**Responses to
the Examining Authority's Written Questions
on Behalf of the**

Neighbours and Users of Queen Elizabeth Park

Interested Party reference no: **20022545**

This document contains responses to some of the Examining Authority's Written Questions (ExQ1), which were issued on 16 October 2019.

Drawing title: **WORKS PLAN SHEET 56 REGULATION 5 (2)(J)**

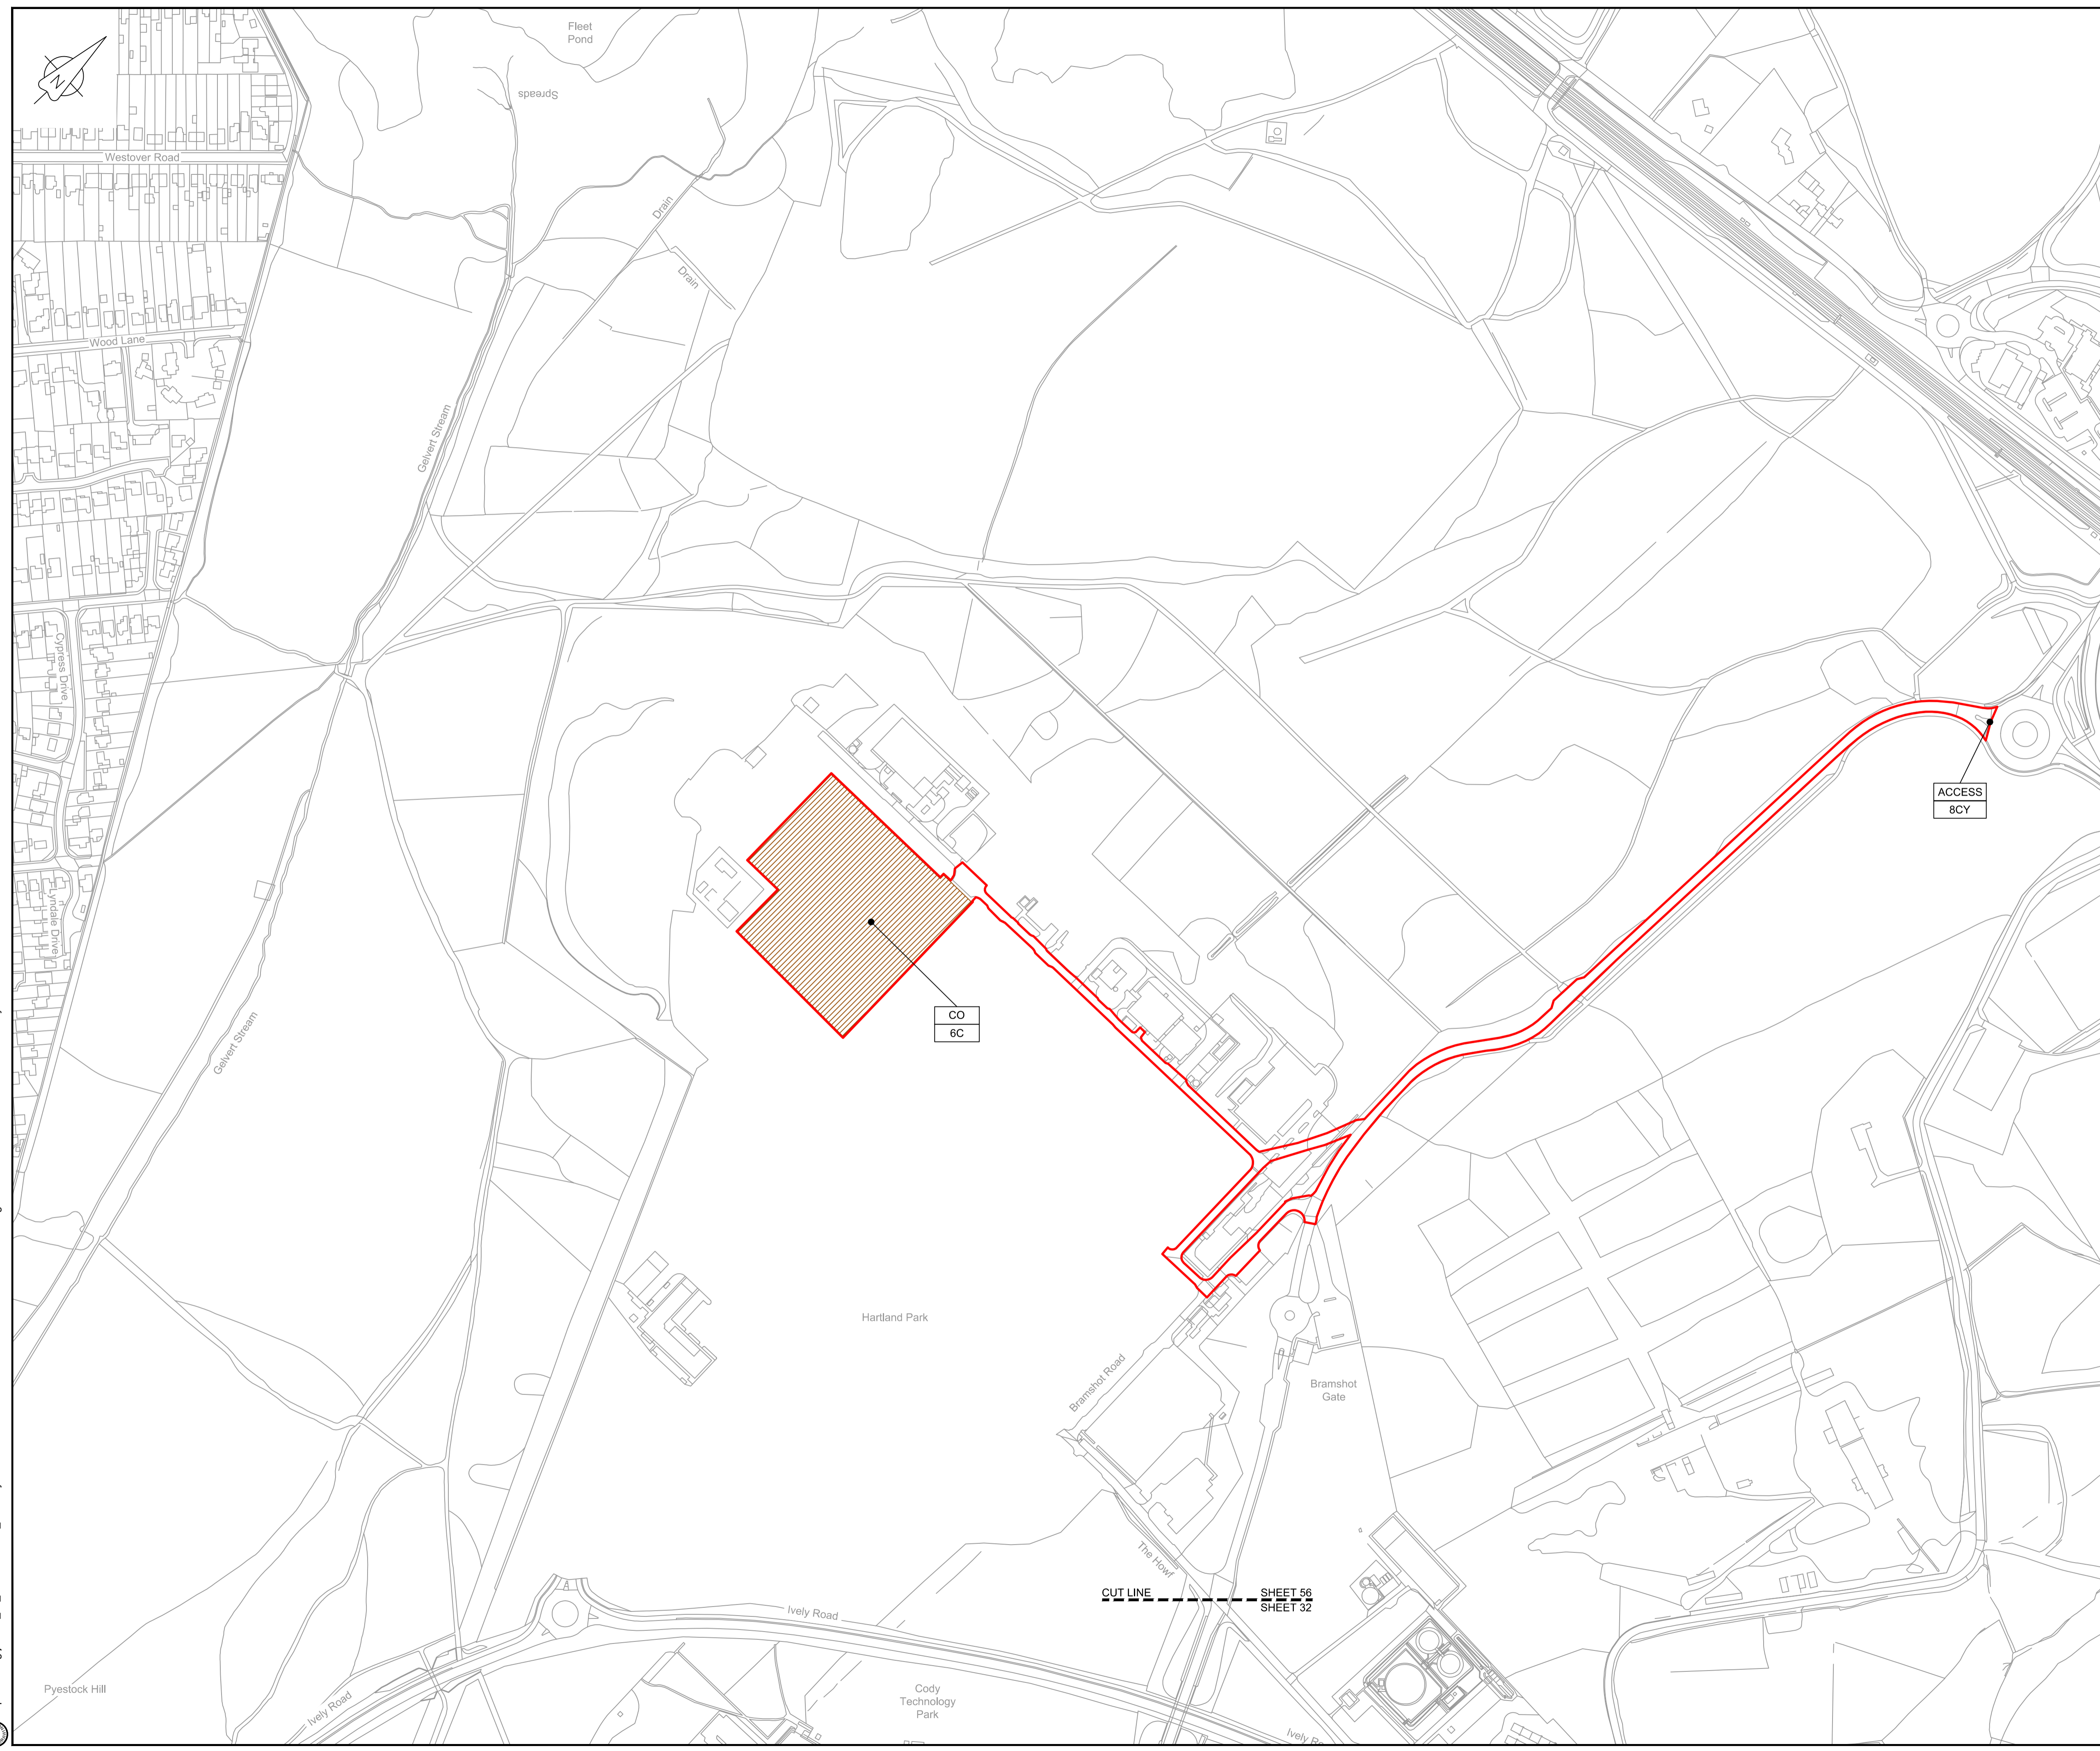
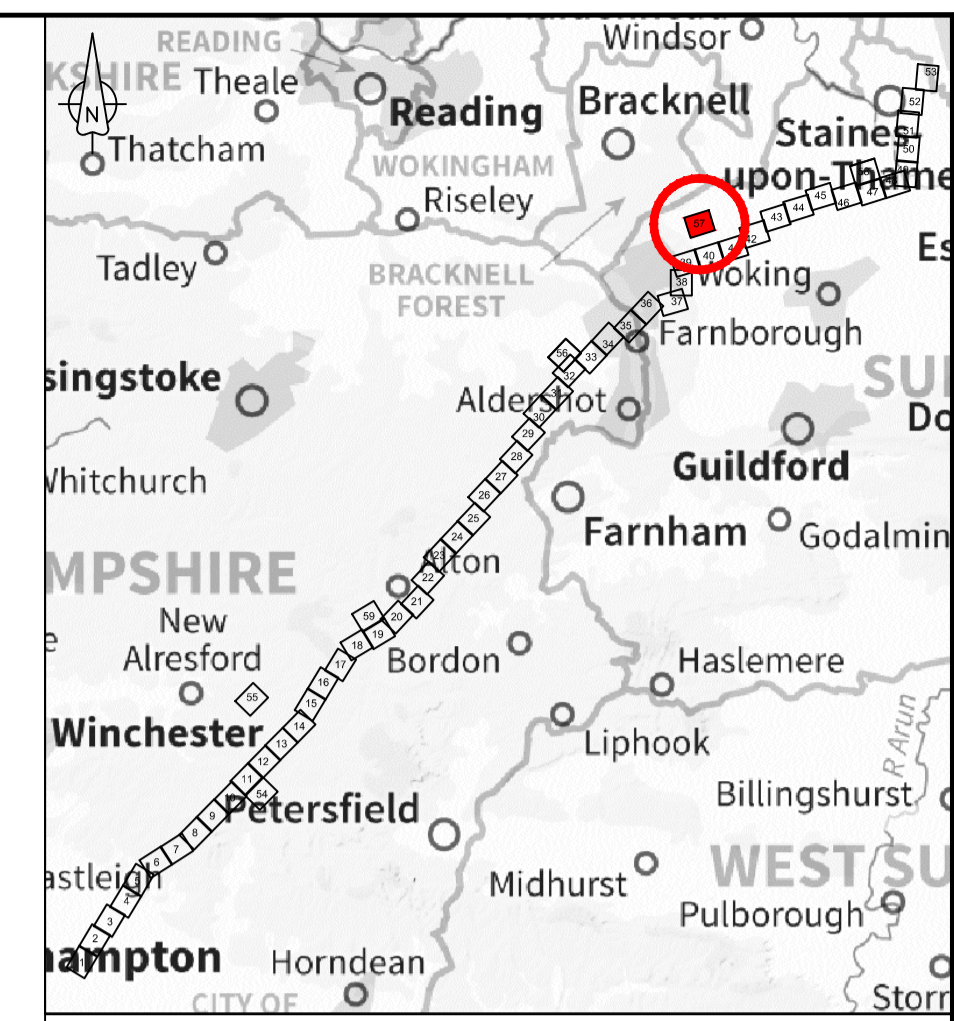
It has been confirmed that the play area will be removed for the (unknown) duration of the project, but the DCO does not confirm the temporary replacement because currently no suitable alternative location has been identified.

Residents do not want to lose the use of a play area during the project.
